2024/0026

Description: Retrospective application for the erection of a detached car port to front of single storey semi-detached dwelling

DRG No CAD/001

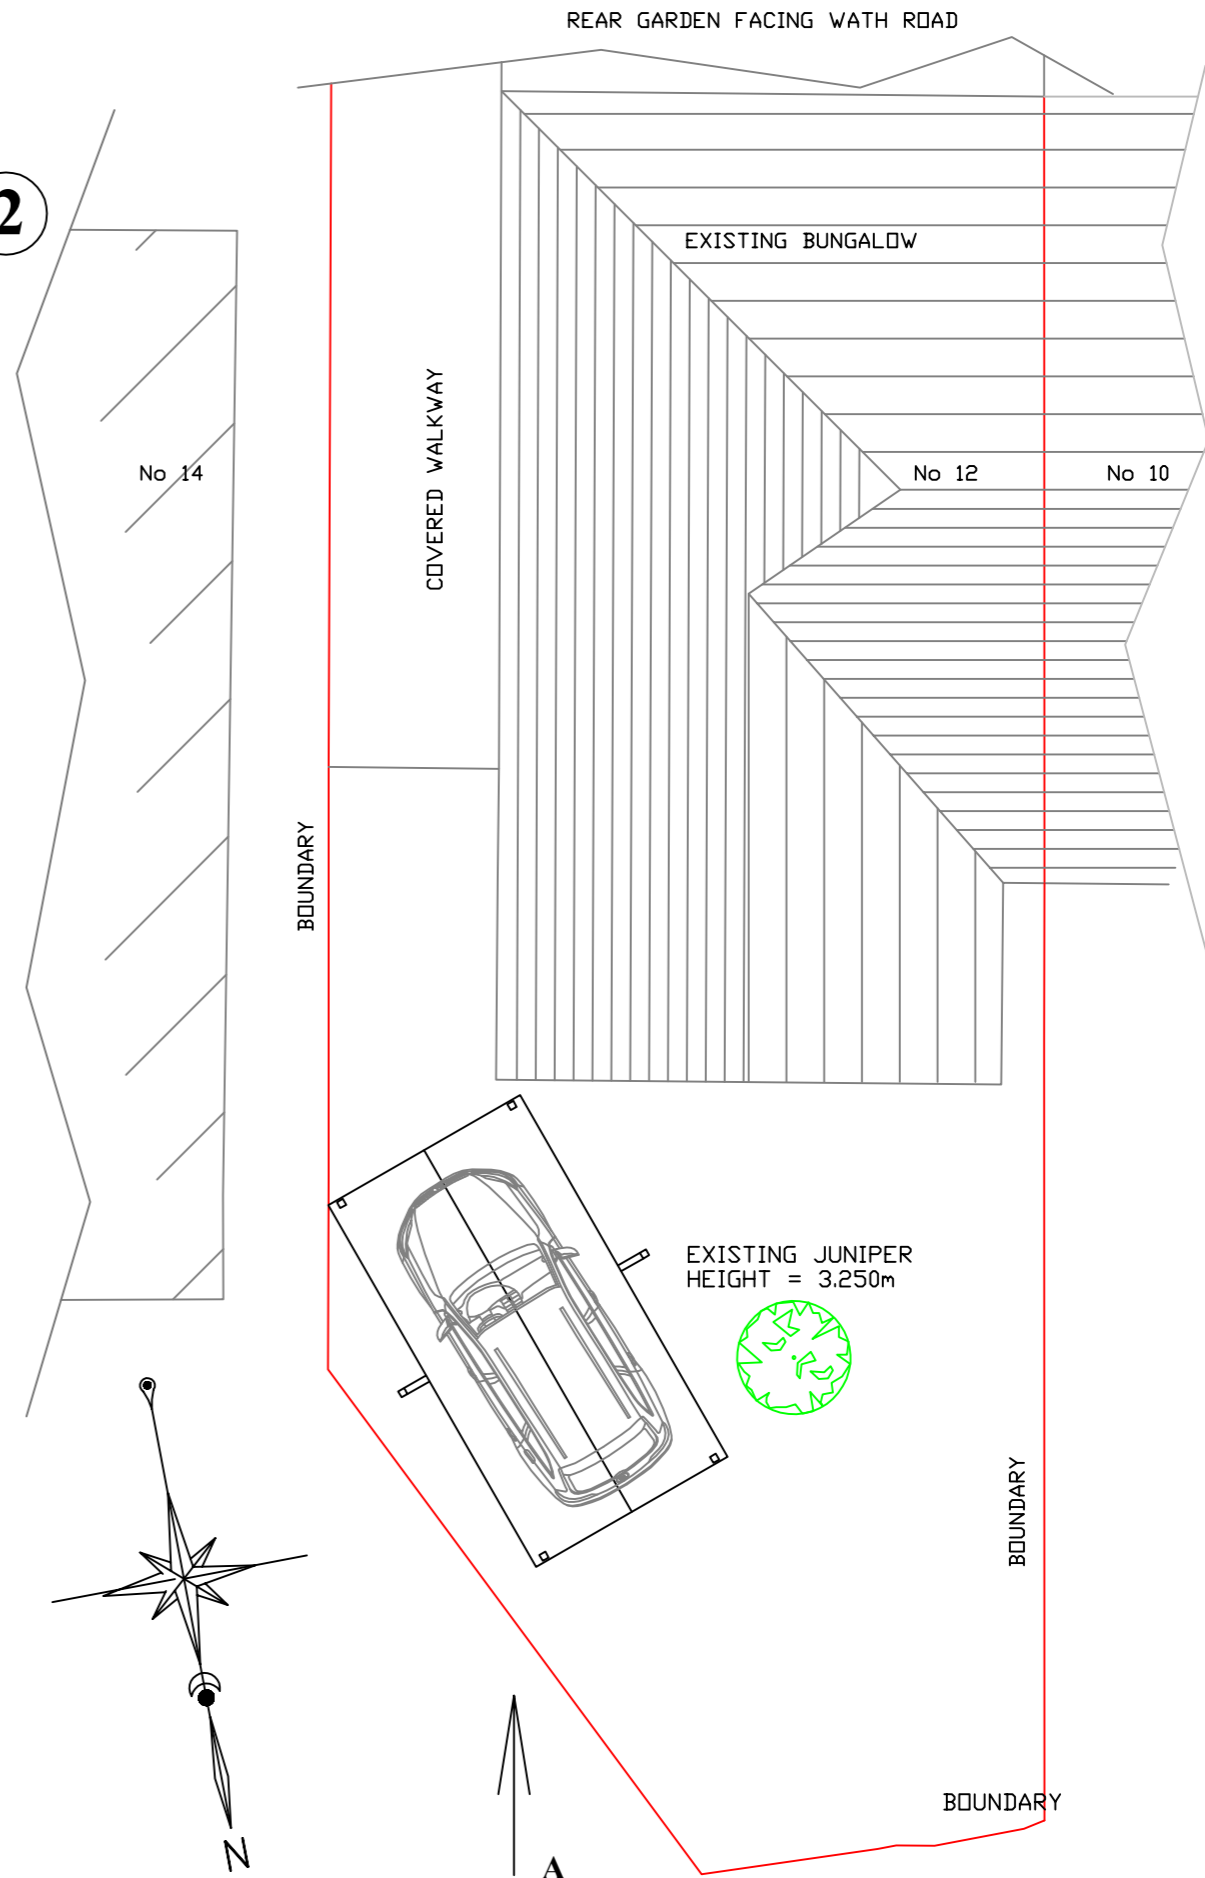
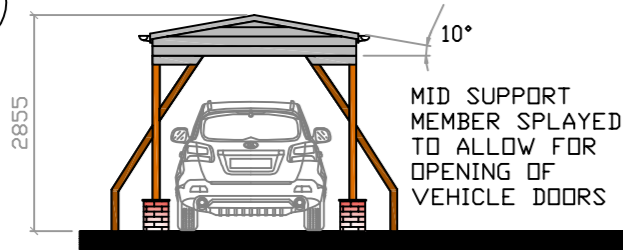
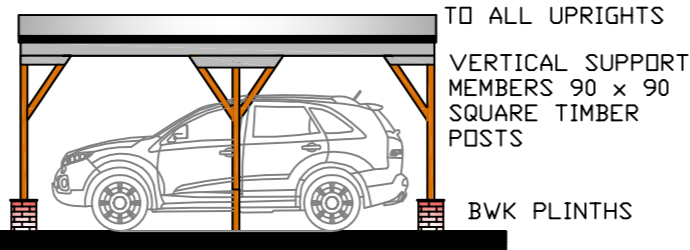
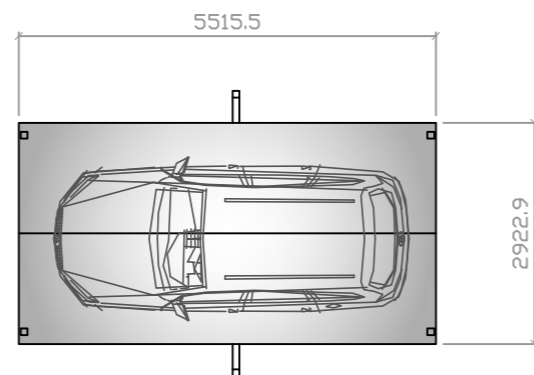
Due to the open nature of its design, the proposal does not cause any significant harm to the residential amenity of any neighbouring dwelling, such as overshadowing or to the broader street scene but a moderate amount of harm to the outlook of the unattached neighbouring dwelling must be considered. In line with paragraph 8.9 of the Local Plan policy GD1 which mentions in “consideration of whether structures in close proximity to windows are considered visually over dominant”, as the structure is considerably close to the boundary between the two dwellings and is also located close to the side and front windows of the same neighbouring dwelling, there would be some loss of outlook caused by the car port.

The above policy outlines the importance of the impact of any structure in front of the principal elevation of a dwelling, and particularly in the relation to garages located within the area between the principal elevation and road. Whilst the structure in question is a car port, as mentioned above whilst it is not possible to define every type of structure, the nature of car port and specifically its purpose would be akin of that of a garage. Regardless of the determination of the structure itself, any extension, which again may relate to something not physically attached to the dwelling would “not be considered acceptable where they detract from the quality of the existing dwelling or character of the street scene”. Policy D1 further requires that “Development is expected to be of high quality design and will be expected to respect, take advantage of and reinforce the distinctive, local character and features of Barnsley” and “Display architectural quality and express proposed uses through its composition, scale, form, proportions and arrangement of materials, colours and detail”. In this instance, it is considered that the scale and siting of the car port alters the character of the original by overwhelming it in an unsympathetic manner

Although the street scene is secluded, in the respect it resides in isolation with a single point of access of the main road, the majority of dwellings on the small cul-de-sac are bungalows of a similar design with garages, including at the application dwelling, located at the side and to the rear of the principle elevation. Furthermore, except for the small terrace of three houses, all the bungalows feature a similar front elevation, with no door or porch on the front elevation. There is therefore nothing of similar design and scale within the street scene which could mitigate the dominance of the structure and as such it appears a prominent and discordant feature to the detriment of the character of the street scene. es.

Following assessment of its potential impact upon the amenity of the neighbouring dwellings, particularly the effect of loss of outlook for the unattached adjacent neighbour, and with the overall negative impact the structure would have on the visual amenity of the street scene, the proposal would be significantly out of character and has the potential to cause significant harm to character of the original dwelling and the street scene, especially if allowed to set a precedent for similar structures to be erected beyond the front elevation of neighbouring dwellings.

Recommendation: Refuse
